Recommendation Report for Planning Permission for Works or Extension to a Dwelling

REF NO: AW/364/20/HH

LOCATION: 23 Rose Green Road
Rose Green
PO21 3EU

PROPOSAL: Loft conversion to form new first floor with front and rear dormer projections.
Retrospective permission for single storey rear extension.

Ground floor plan

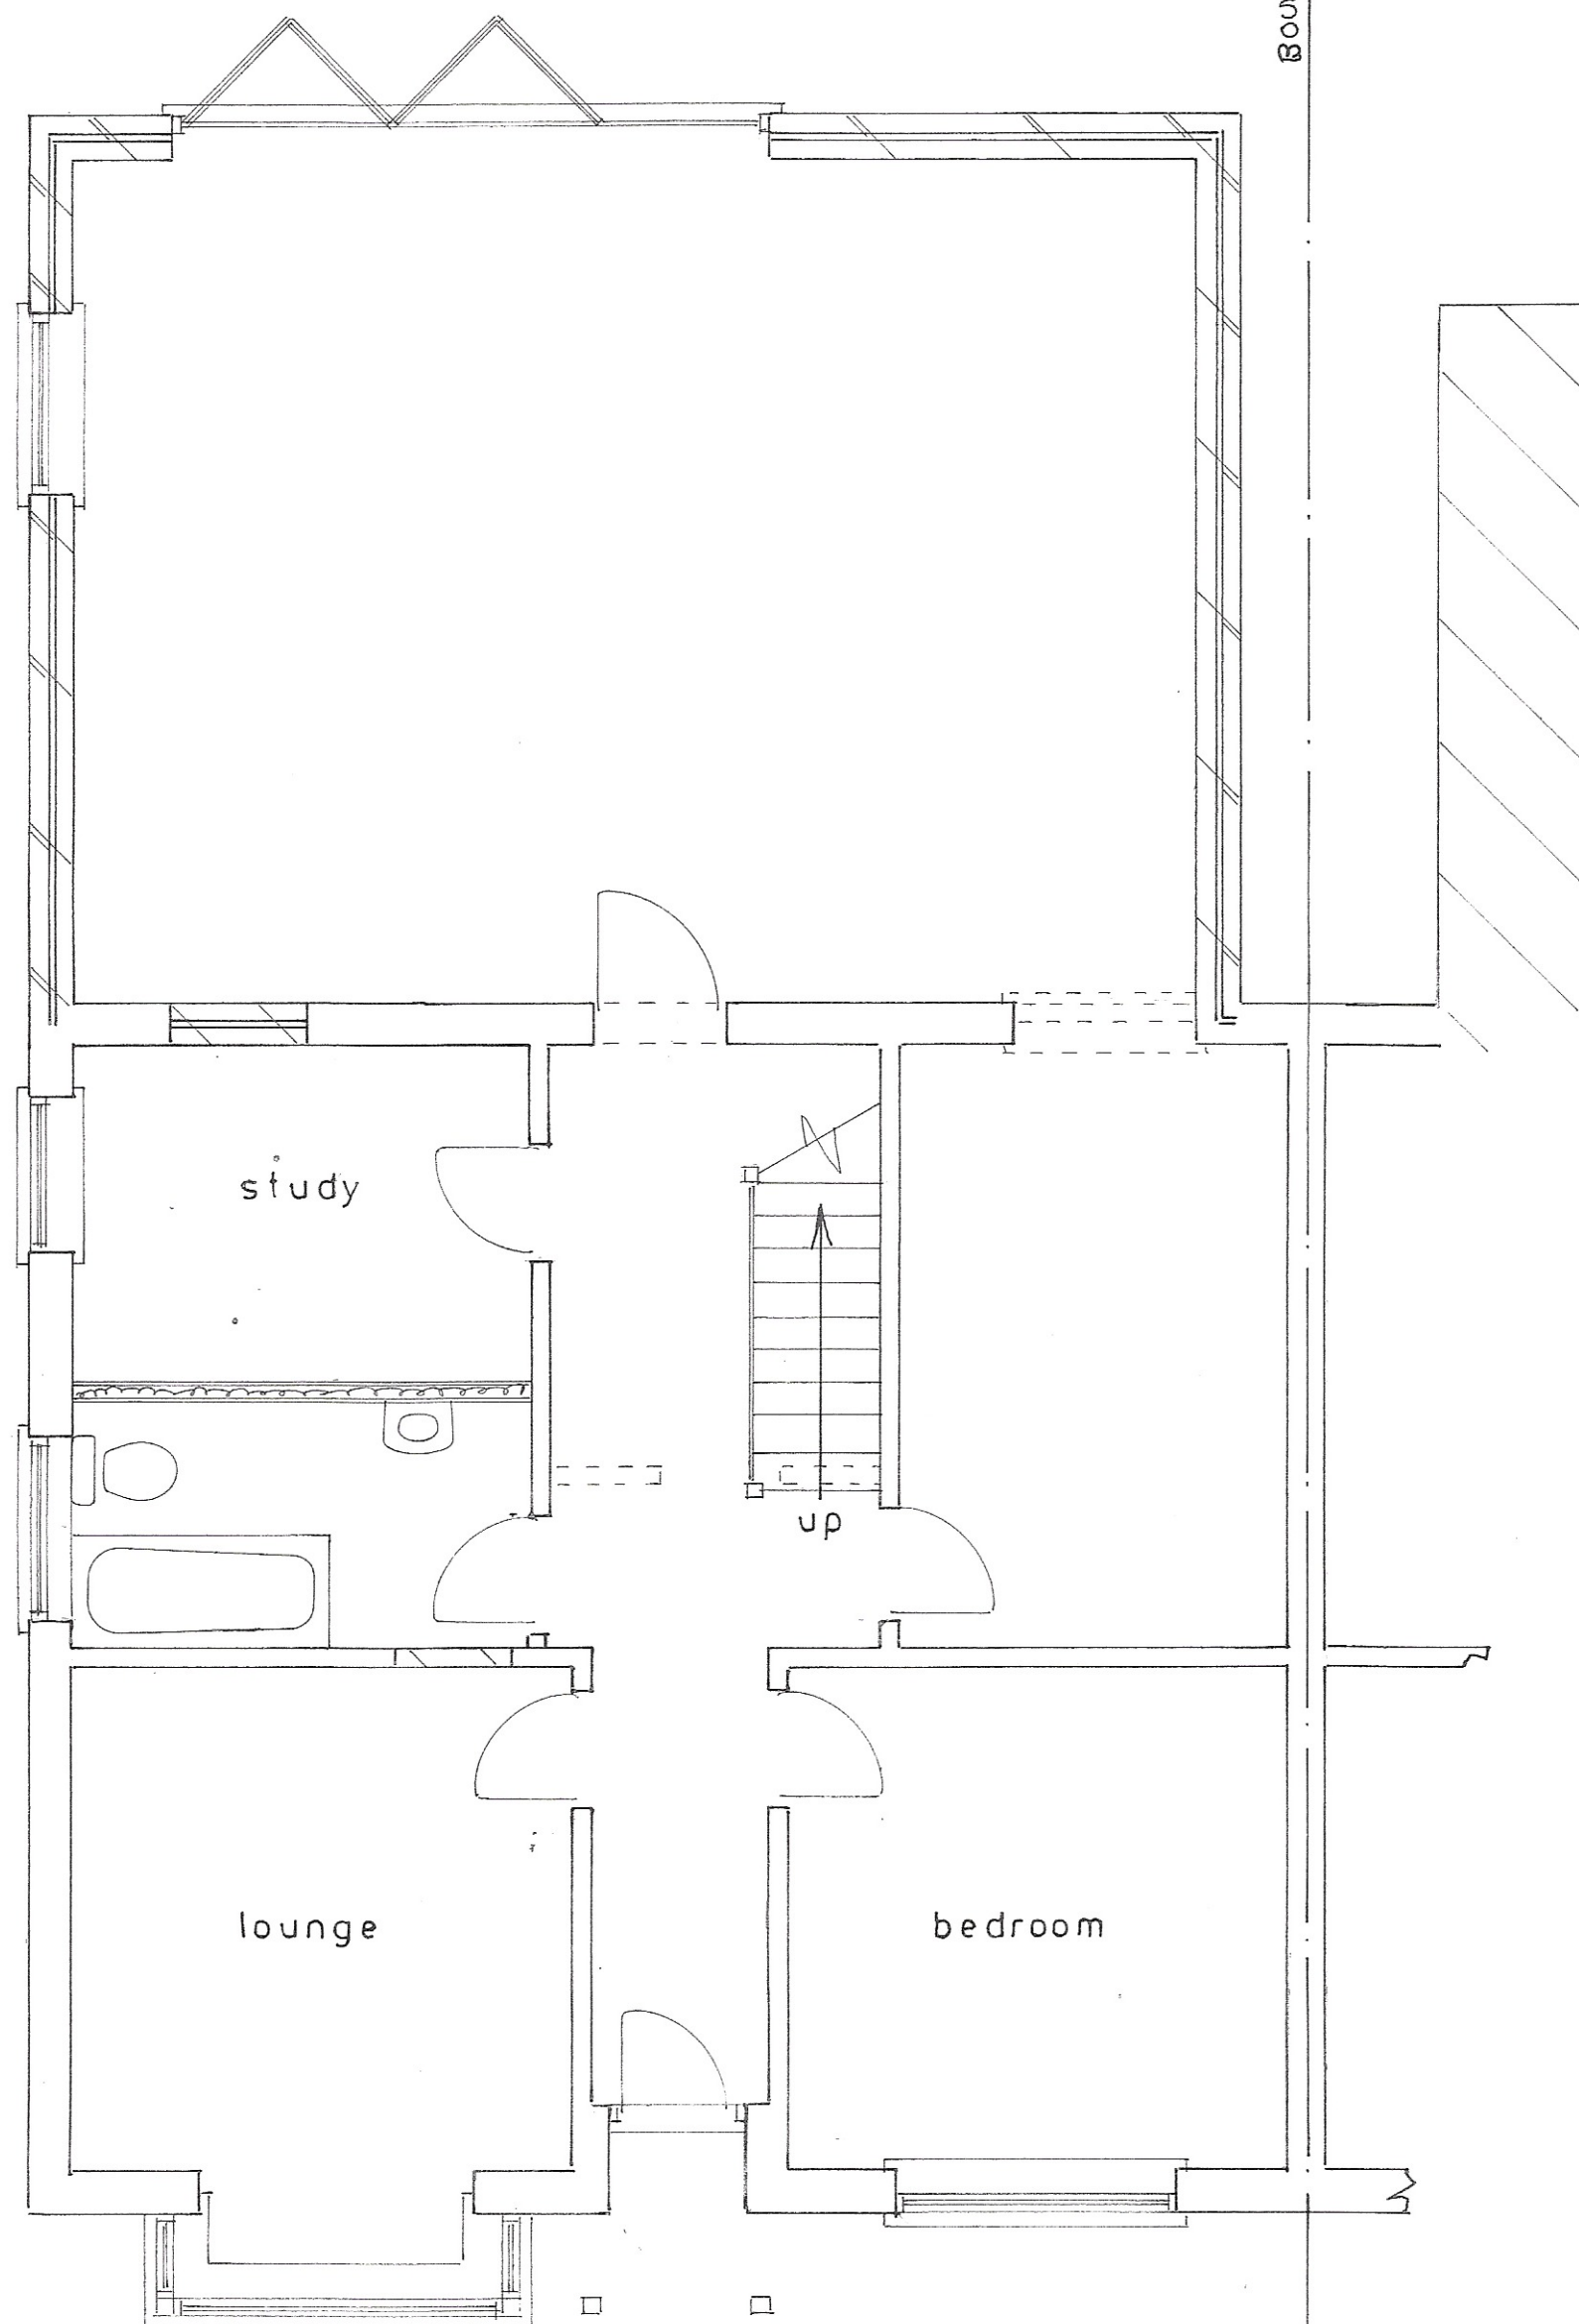
The extension will be sited to the rear of the property and as a result of its siting, is unlikely to be visible from the street scene and could be completed under the permitted development rights of the property having a depth of 6m and a width of 8m. The extension is considered well integrated and sympathetic in design to the host dwelling. The materials will also match that of the host dwelling ensuring its integration.

The extension will have a maximum depth of 6m and a width of 8m. The height will match that of the host dwelling with eaves at 2.85m.

It will extend in line with the south eastern elevation and whilst this adds bulk to the rear, due to its siting, sufficient distance is retained to the boundaries with 0.45m to the north, 2.7m to the south and 18.5m west. The development is therefore not considered to appear adversely overbearing.

There will be a number of additional windows and doors to the south and western elevations, however these will all be at ground floor level and with fencing along the boundary, and with views over the garden, it is not considered to give rise to adverse overlooking.

sheet 2 of 3

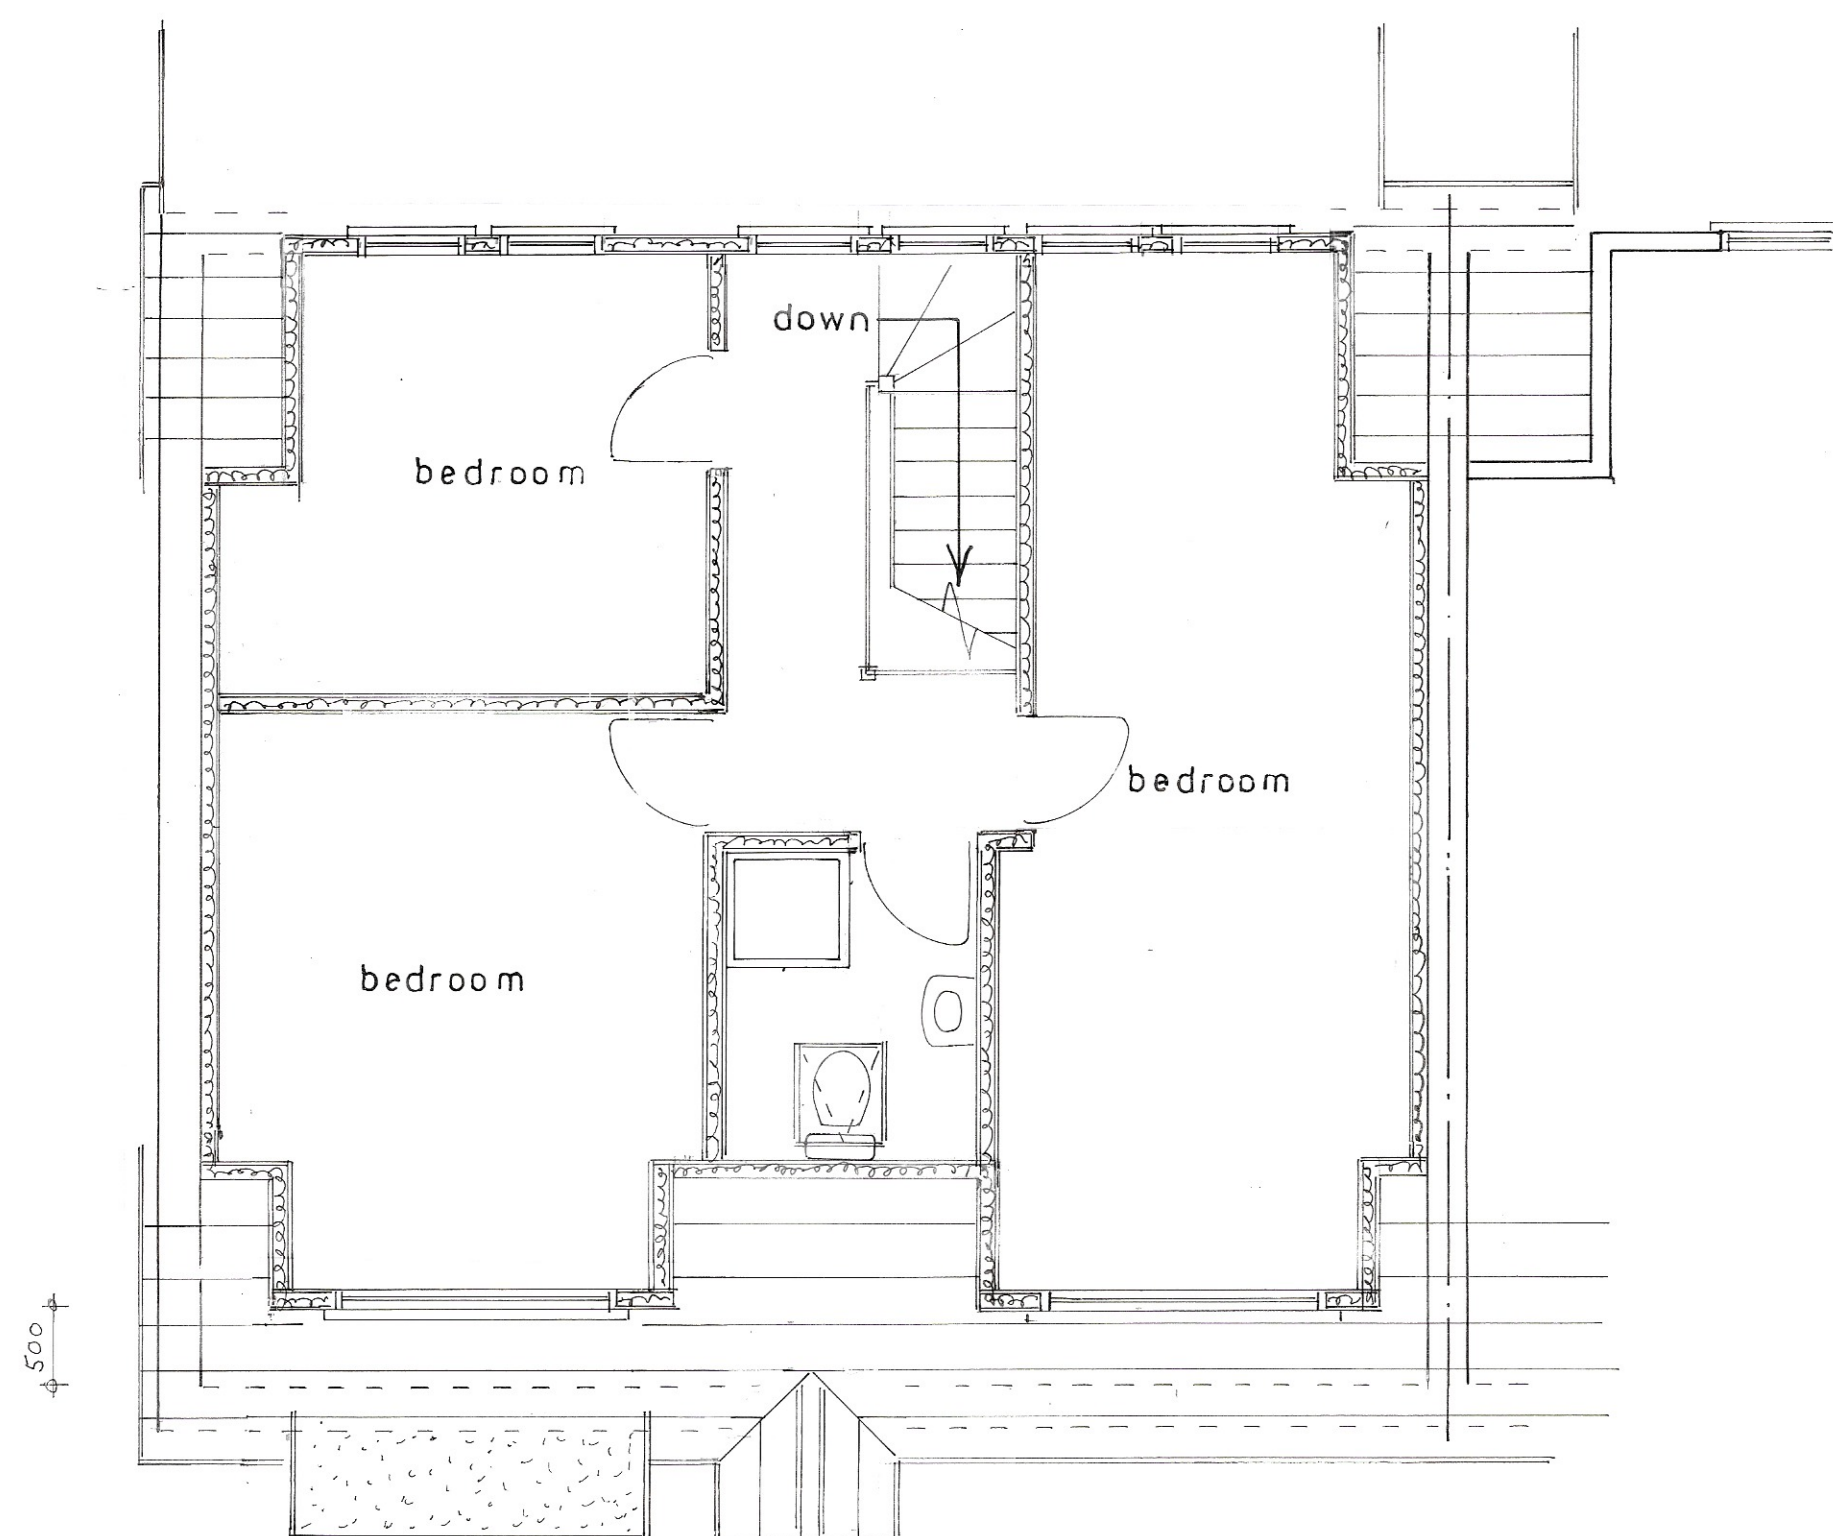
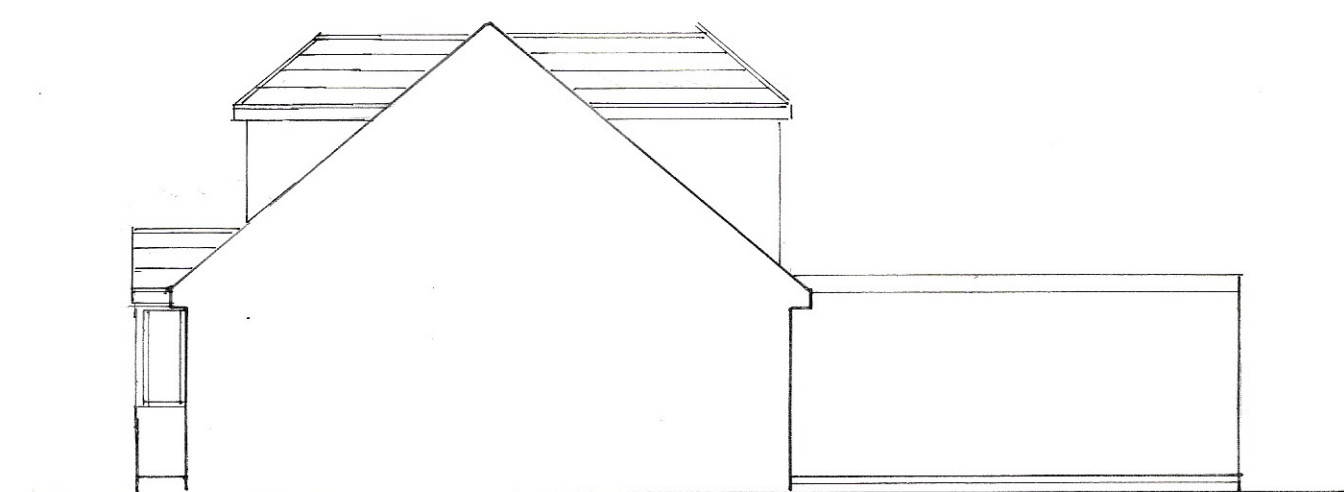
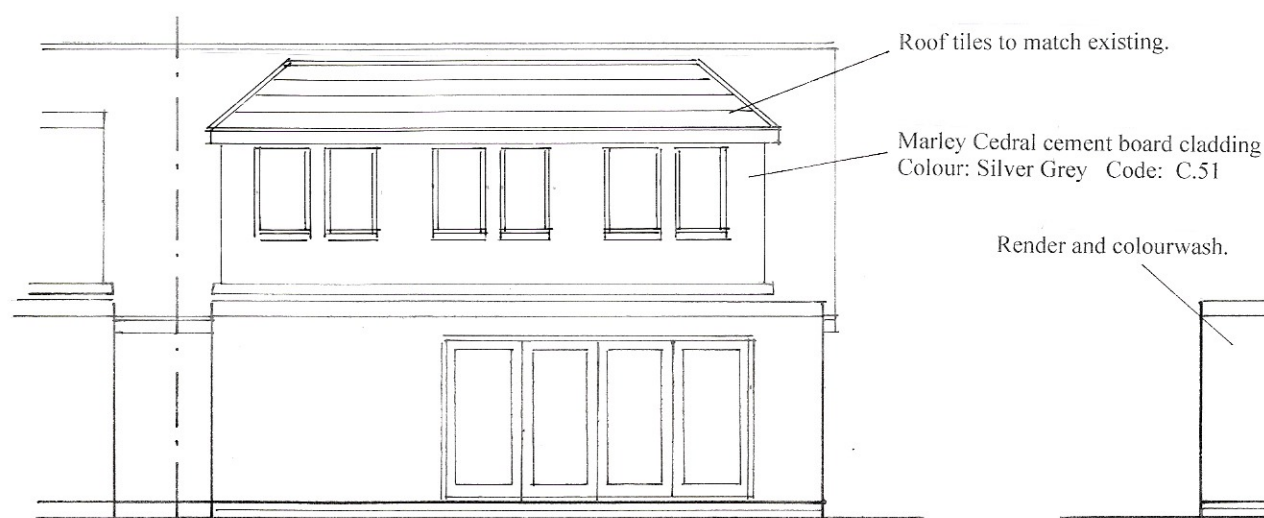
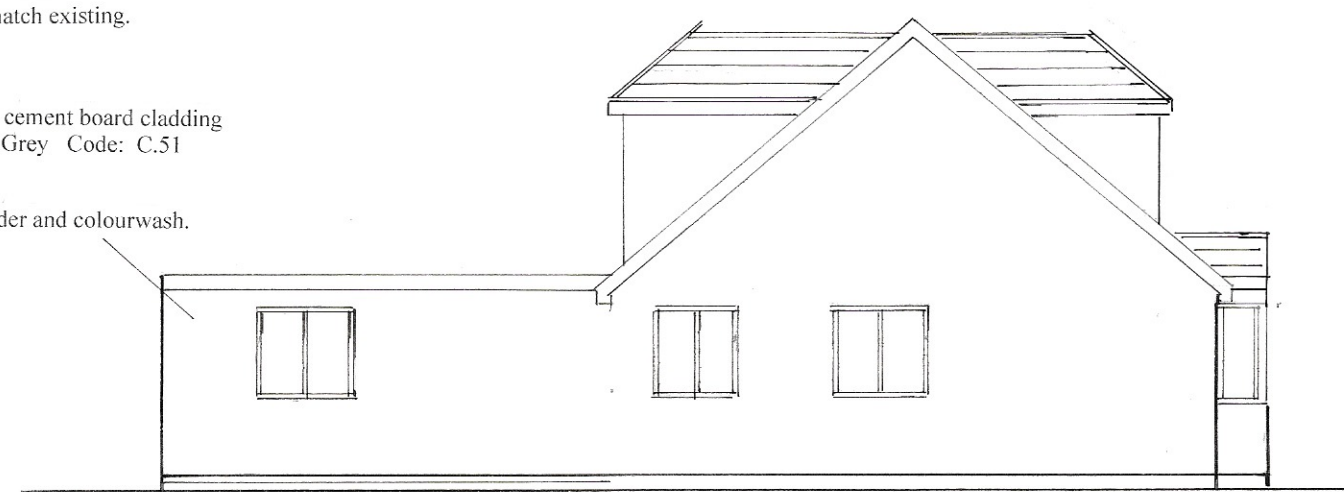
The dormers will be located to the front and rear of the property and will be visible from the wider area. To the rear the dormer will mirror that of the neighbouring property as such the alteration is not considered to result in the dwelling appearing significantly out of character for the area as there is already a precedent for works of this nature.

Materials consist of roof tiles which match the dwelling and Marley Cedral weatherboarding. Cladding will be used to the on the elevations of the dormer whilst this is a new material due to its location to the rear visibility of this is limited and the materials are acceptable. The dormers to the front will have hipped which matches that of the host dwelling and helps to ensure it appears well integrated. Furthermore this is a feature that the design guide specifies as desirable for dormers to the principle elevation. The surrounding properties are varied in style and design and whilst the alteration will alter the appearance of the front of the dwelling, it is not considered to appear out of character in the area.

of which would result in a harmful loss of privacy to occupiers of neighbouring dwellings. The views from the rear dormer are likely to be achievable under Permitted Development, and the views from the front dormer are towards the street scene only.
